**STANTON ST QUINTIN
PARISH COUNCIL**

Application by Lime Down Solar Park Ltd for an order granting development consent for the Lime Down Solar Project

I refer to the Applicants response to Relevant Representation Part 1 Document Reference EXAM/9.10

APFP Regulation: APFP Regulation: 5(2)(a)  
Application Doc no.: APP /6.2  
Drawing no.: Figure 13-11

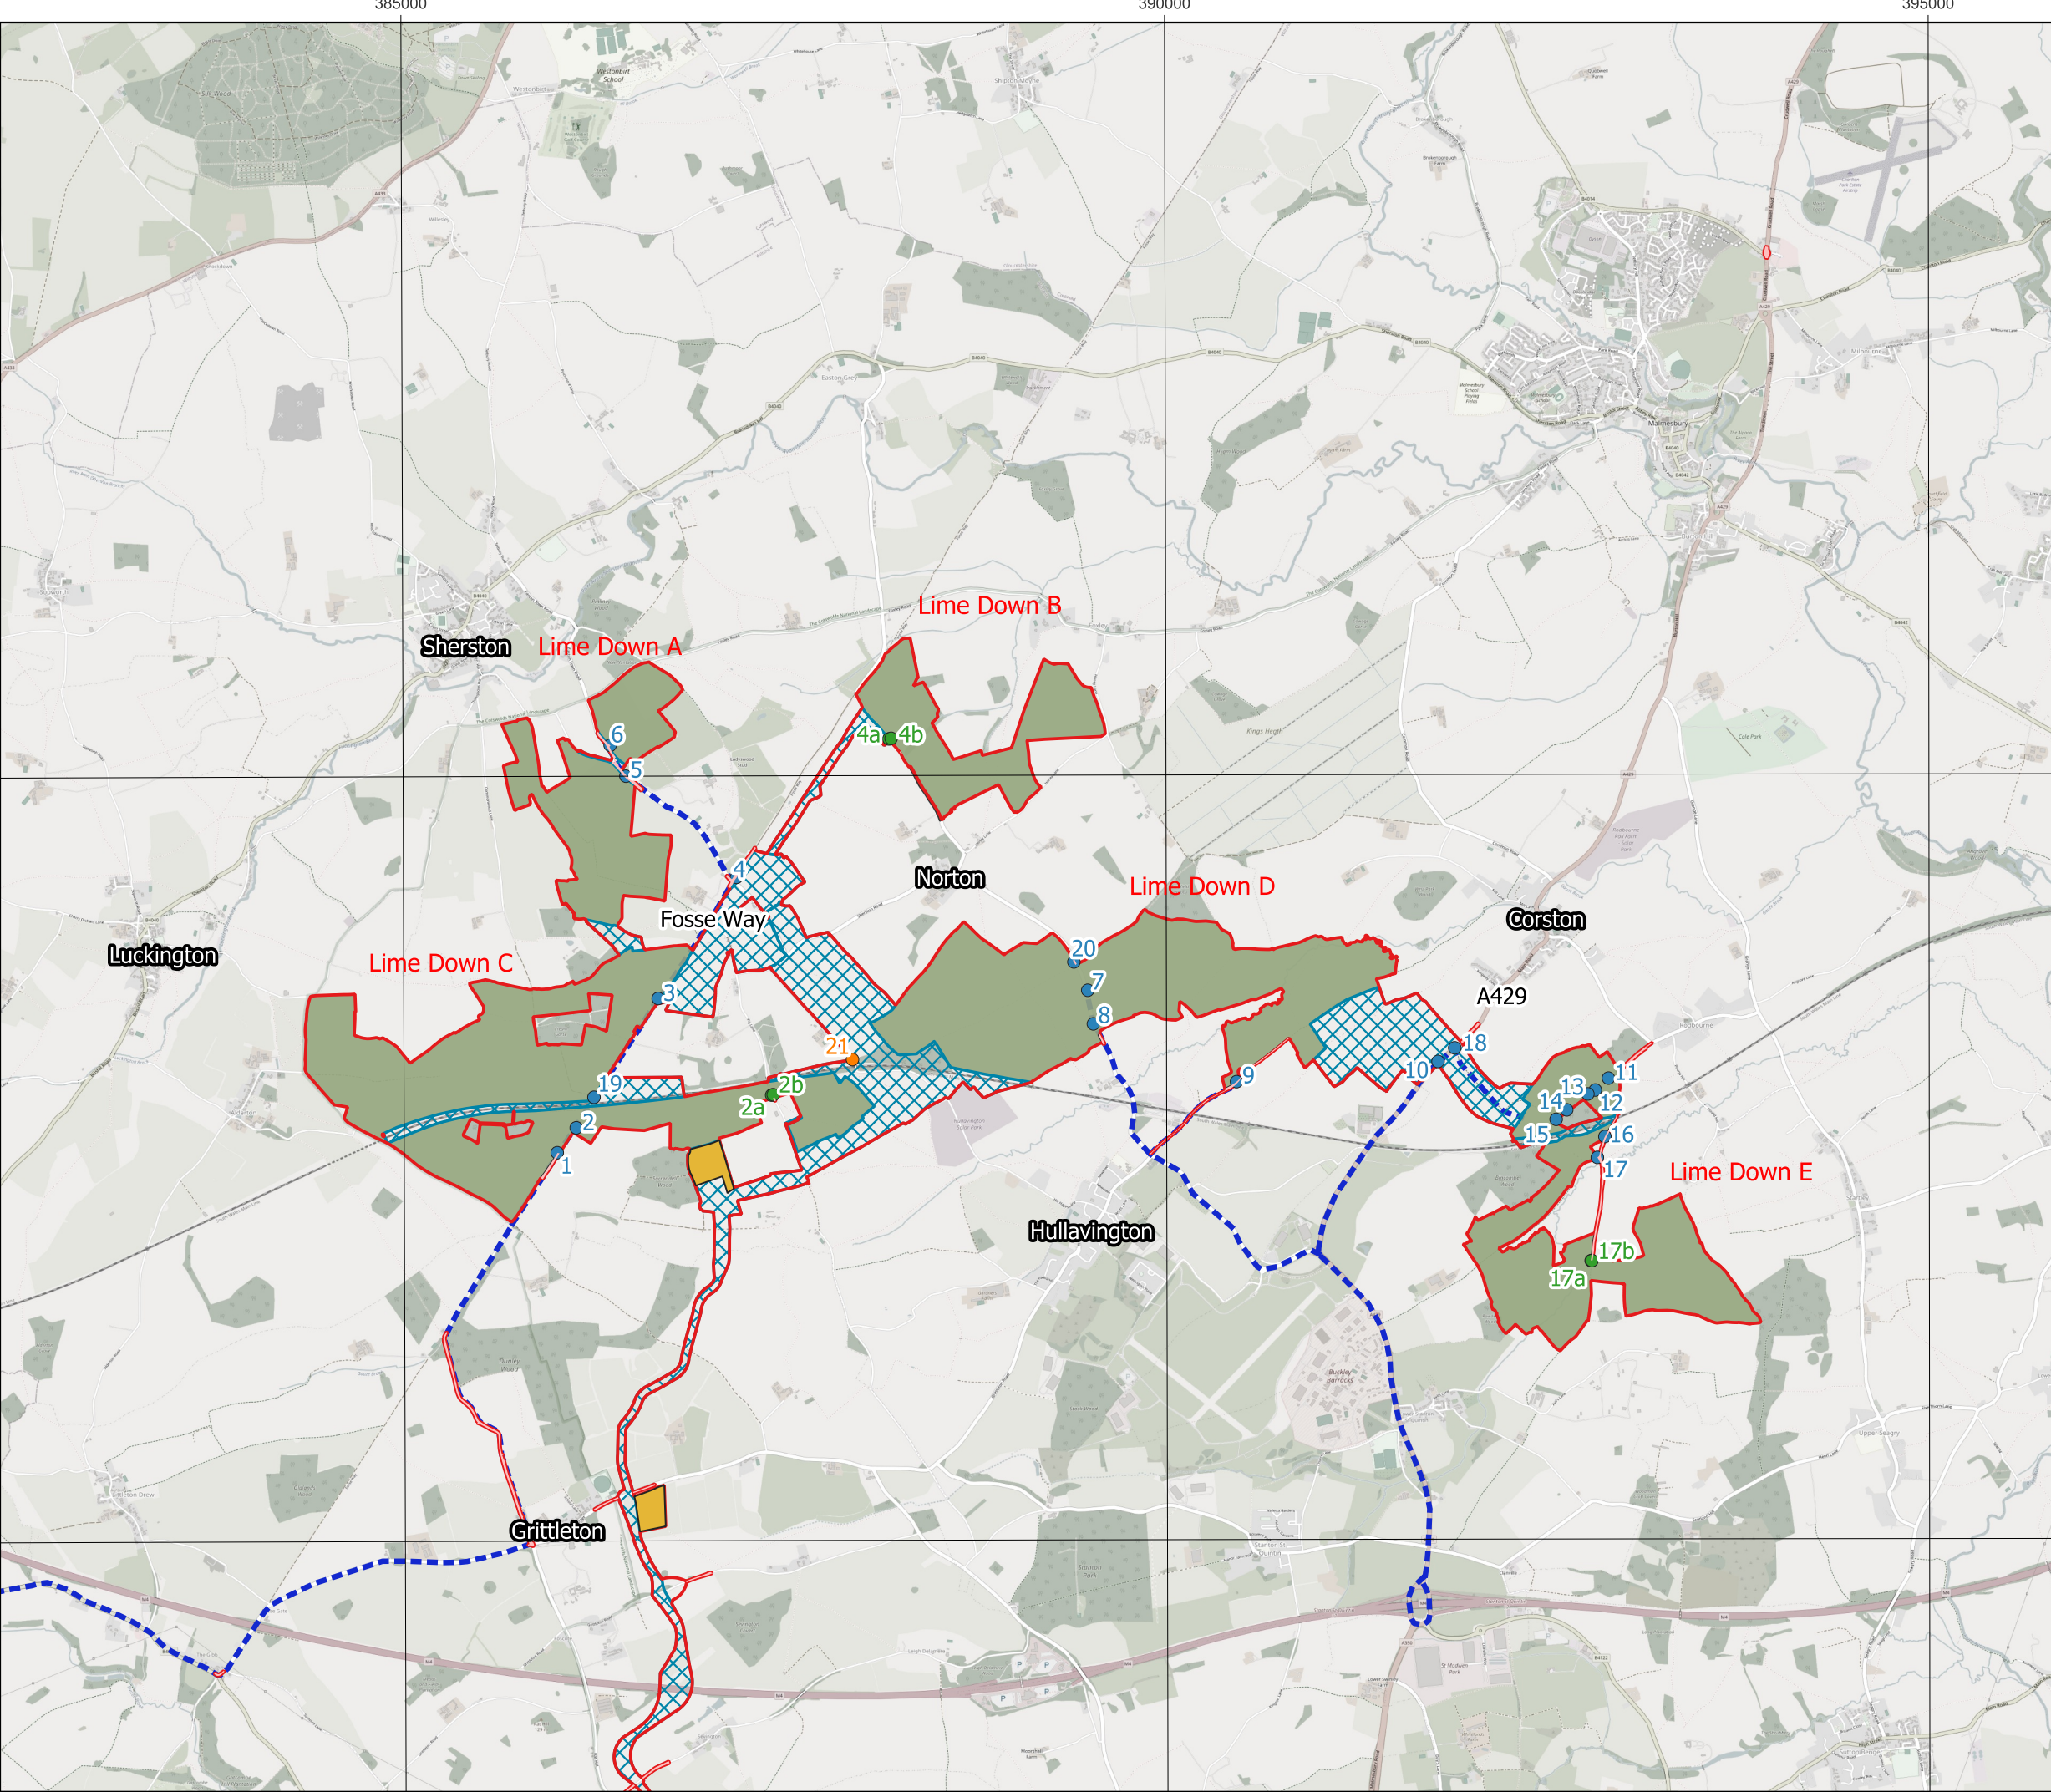
local highway network". What would the "appropriate mitigation" be. How can passing spaces be made in the already narrow lanes and what would happen if two large HFVs meet on these roads? There are numerous blind bends and increased traffic at school times. Would these lorries clear the Kingway bridge? The Parish Council does not believe that the construction traffic can operate without causing access problems to local residents.
